CITY OF ALBUQUERQUE

December 13, 2018

**RE: Harper Senior Living
Grading and Drainage Plan
Engineer's Stamp Date: 11/16/18
Hydrology File: E20D020B**

Based upon the information provided in your submittal received 11/16/2018, the Conceptual Grading Plan and Drainage Report **is not** approved for action by the DRB for Site Plan for Building Permit. The following comments need to be addressed for approval of the above referenced project:

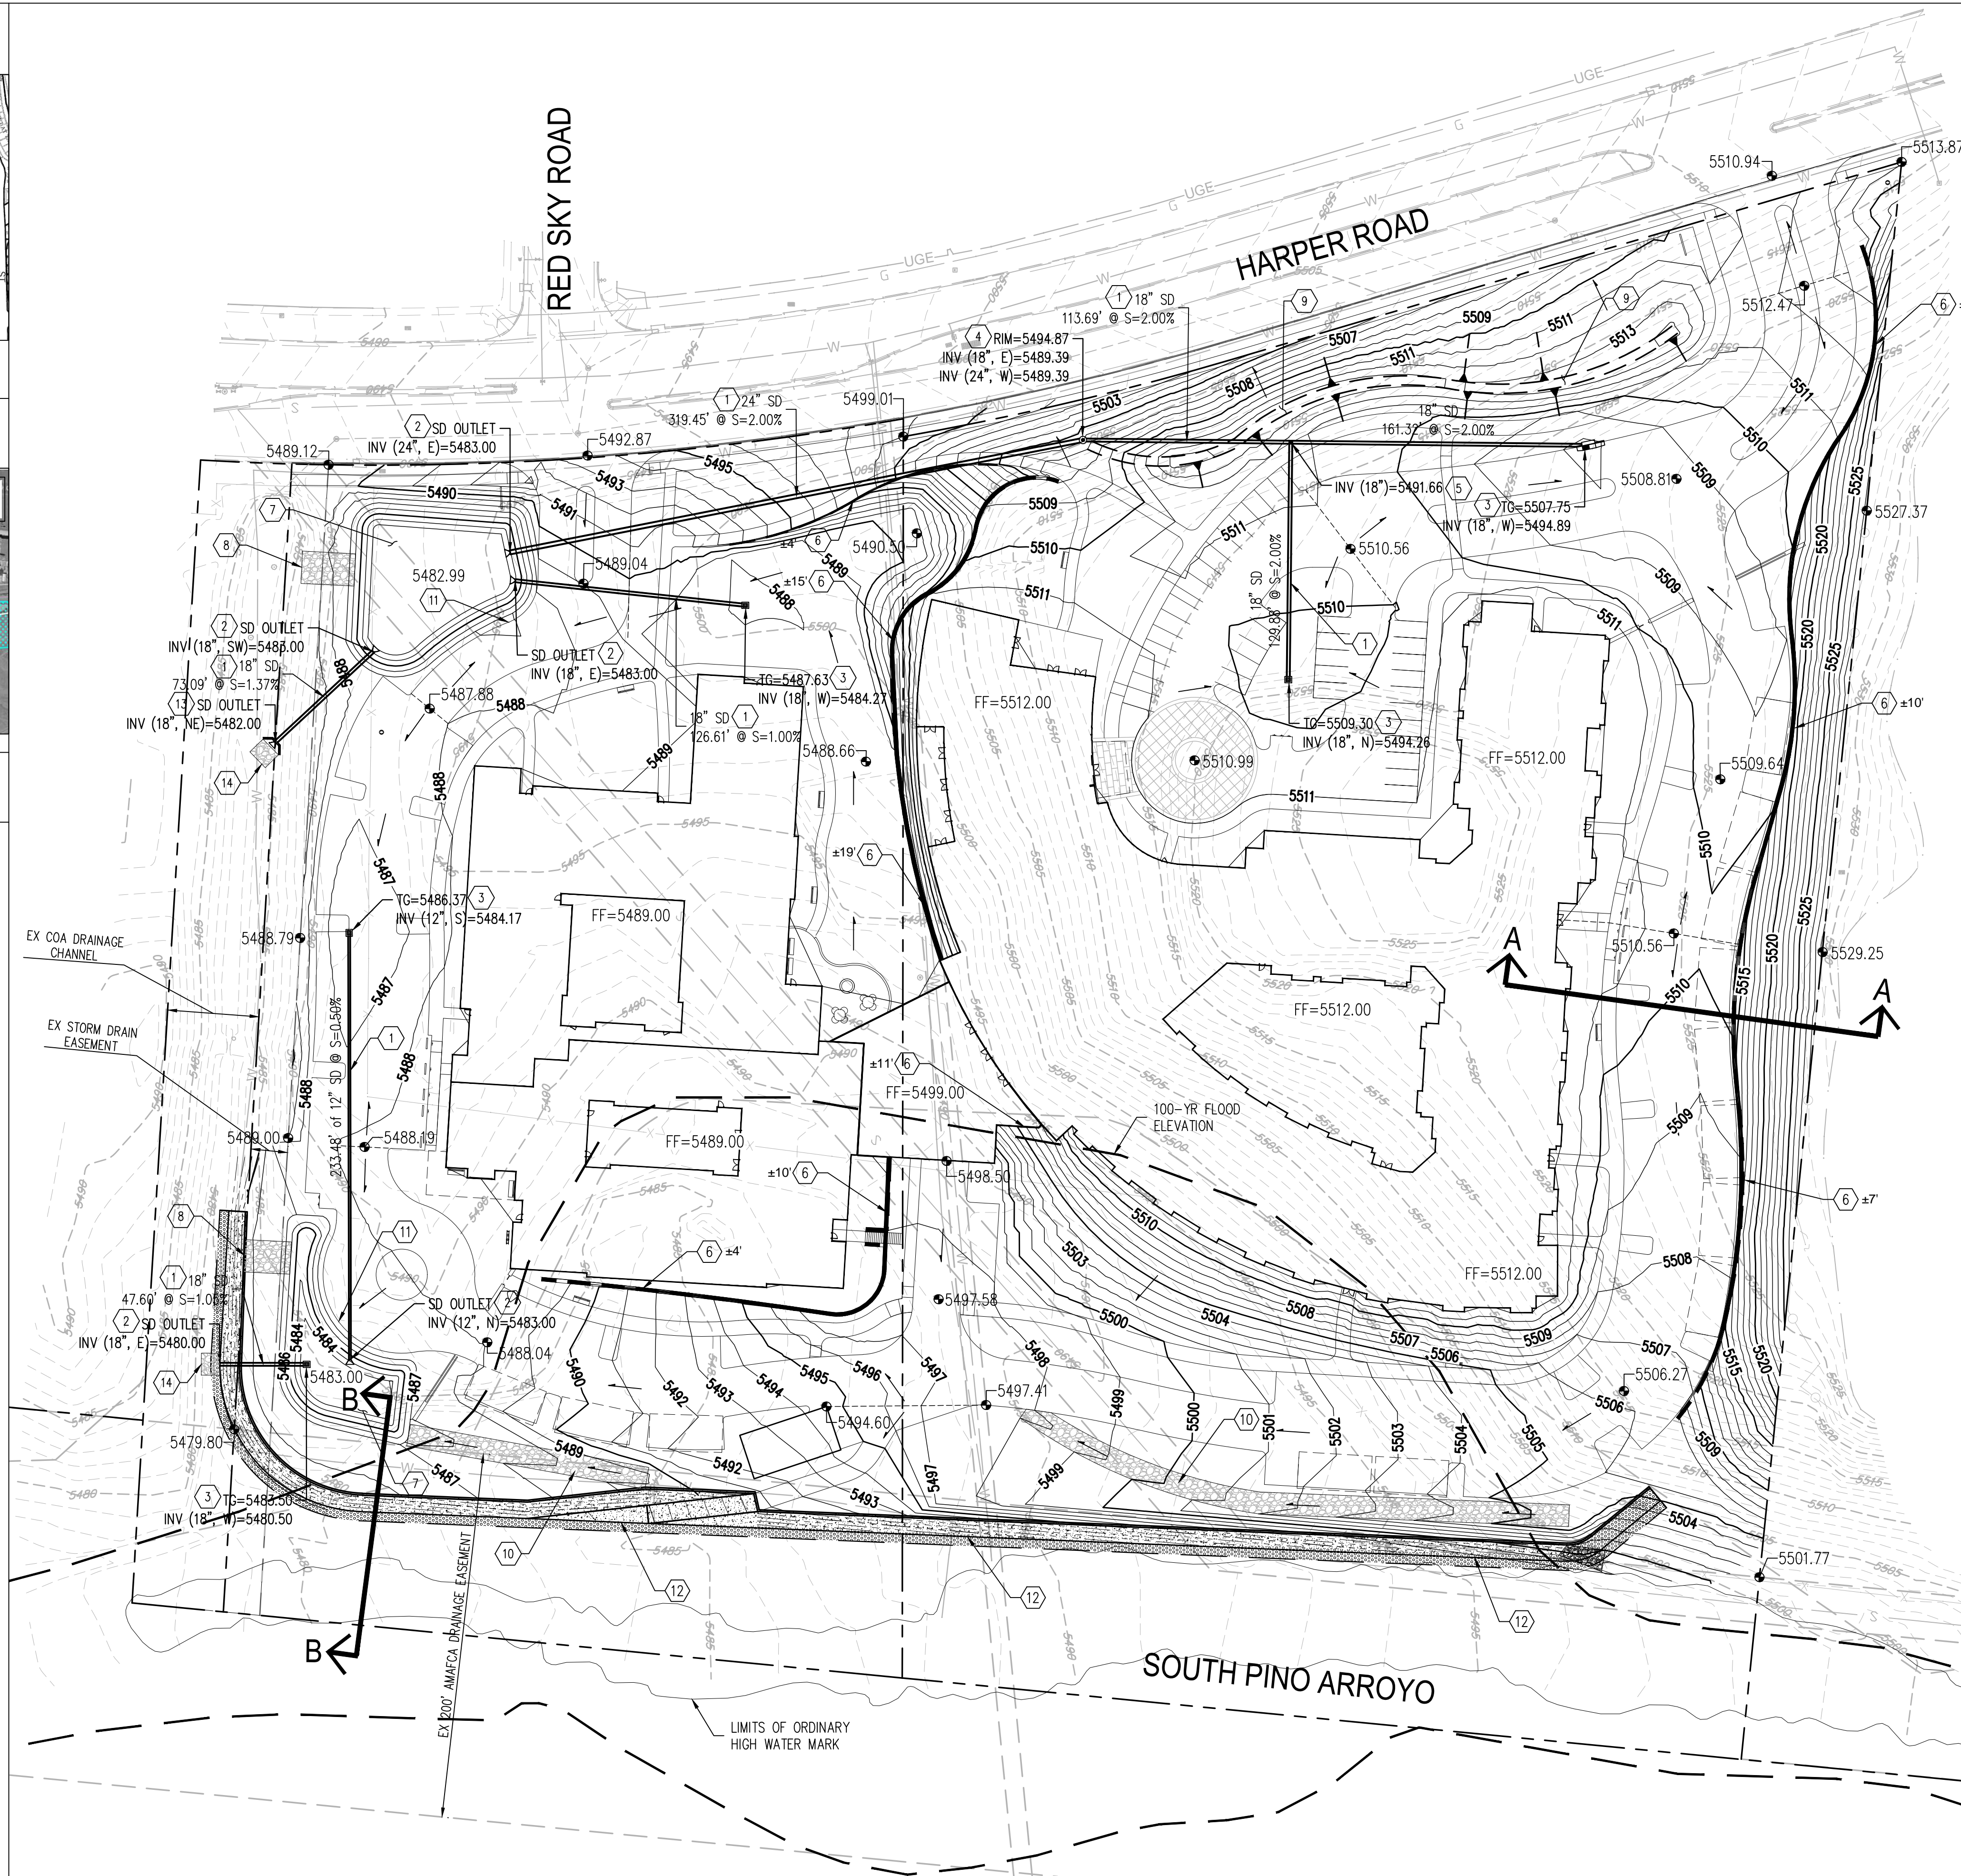
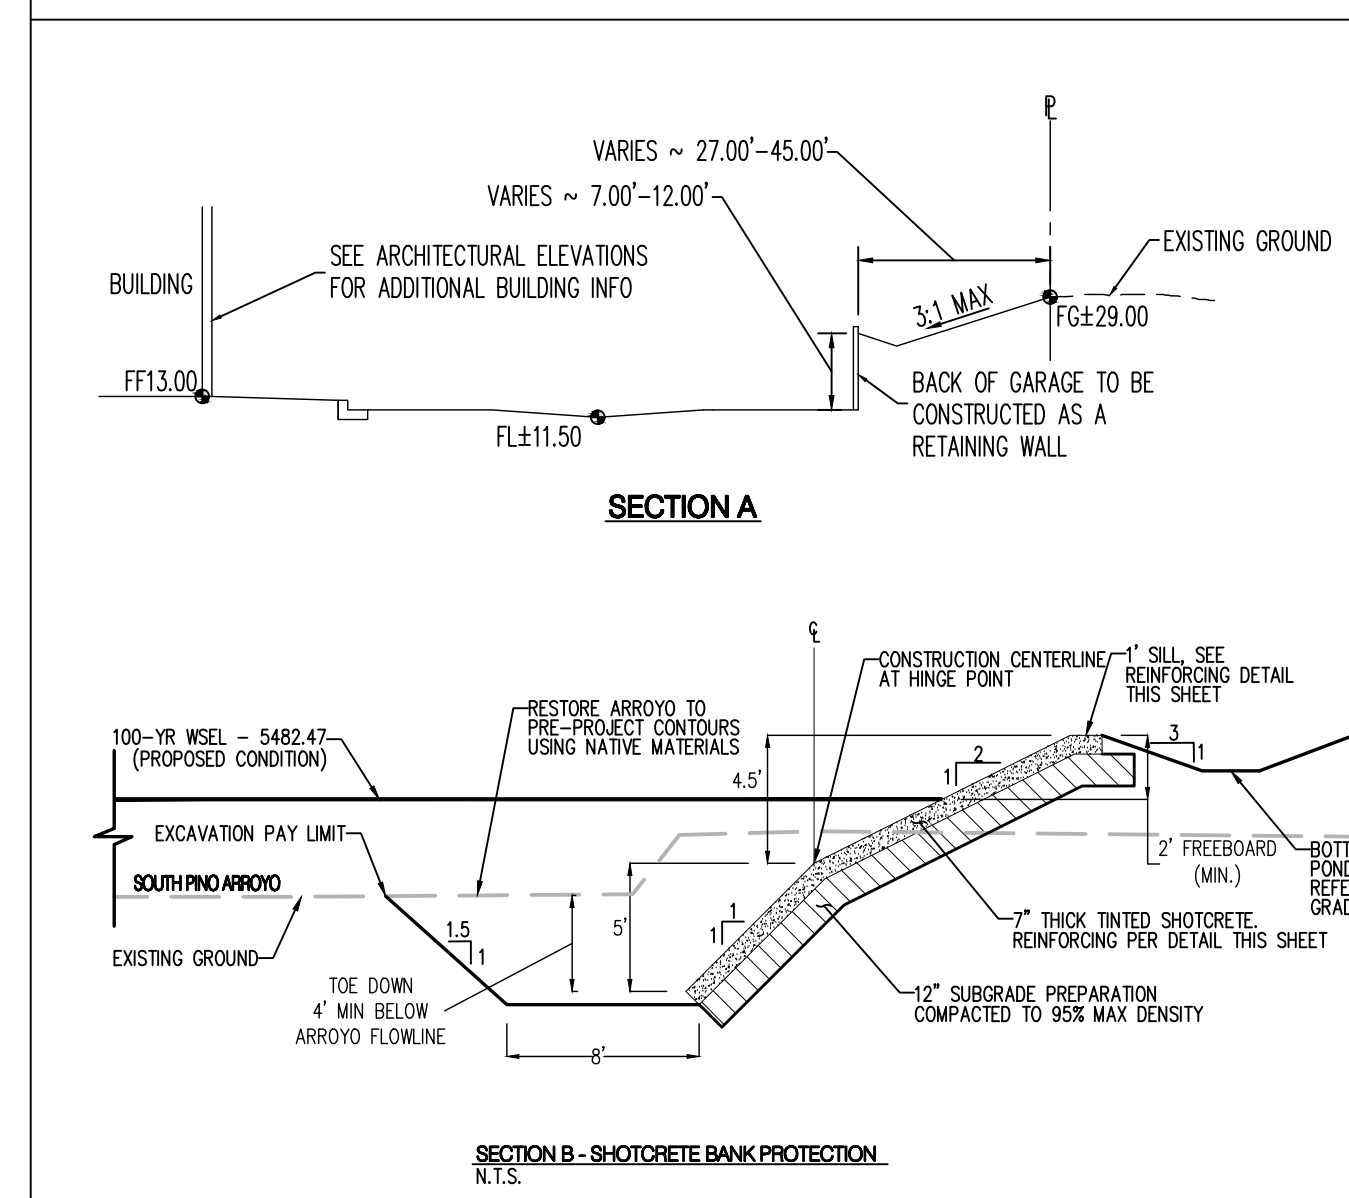
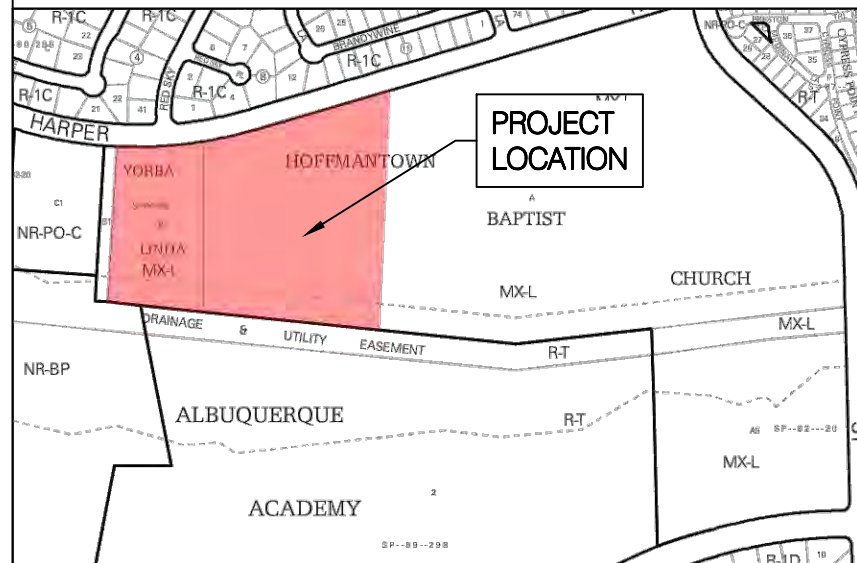
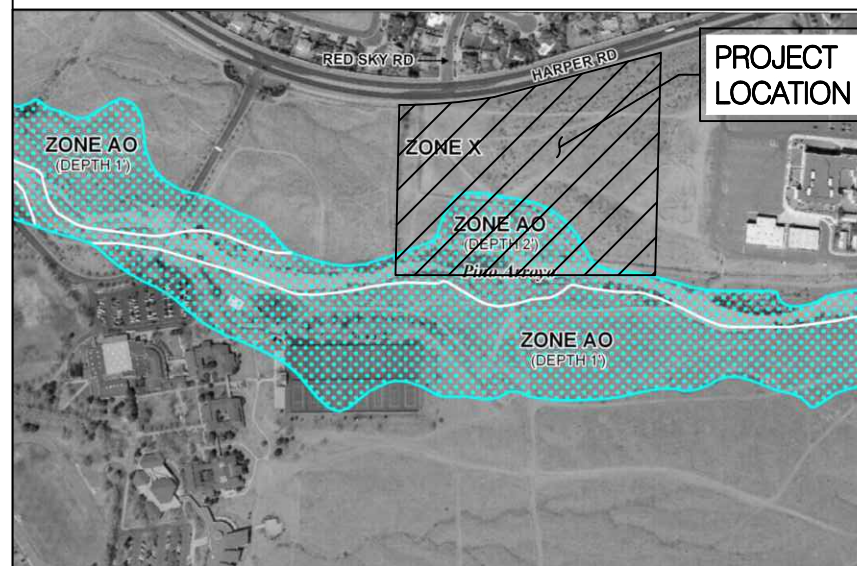
1. Sheet C-100. Please provide the FIRM Map and flood plain note with effective date.
2. Sheet C-100. Please provide a vicinity map showing the location of the site.

3. Sheet C-100. Please provide the legal description of the property.
4. Sheet C-100. Please provide the benchmark information for the survey contour information provided.

5. Sheet C-100. Please label the 100 year flood elevation line. Also please make this a bolder and different line type to differentiate this with the contour lines.

6. All sheets. Please enlarge the existing index contour line text. This text should be at least 0.10 inches high.
7. Sheet C-100. Near the west driveway and on the south side of the sidewalk, the proposed contours are too steep; please provide a retaining wall along this section of the sidewalk.

8. Sheet C-100. Please relocate the outfall pipe for Pond 2 to the east away from the City's drainage ditch's flow line. Also please provide a headwall at the outfall and provide energy dissipation.

9. Sheet C-100. Please wrap the bank protection around and into the City's drainage ditch past the pond. This will stop any erosion.
10. Sheet C-100. Please concrete line the bottom and sides of Pond 1 per AMAFCA's instructions to prevent the bank protection from erosion.
11. Sheet C-100. Please relocate the outfall pipe for Pond 1 to the east away from the City's drainage ditch's flow line. Also this outfall pipe will be thru the bank protection and provide energy dissipation in the South Pino.
12. Sheet C-100. It appears that half of proposed Basin 1 will not find its way into Pond 1 and instead discharge directly into the South Pino Arroyo via AMAFCA's maintenance drive. Please correct grading to insure that the drainage goes to Pond 1 and not down this maintenance drive.
13. Sheet C-100. Please correct Section B to match the bank protection section that was in the CLOMR.
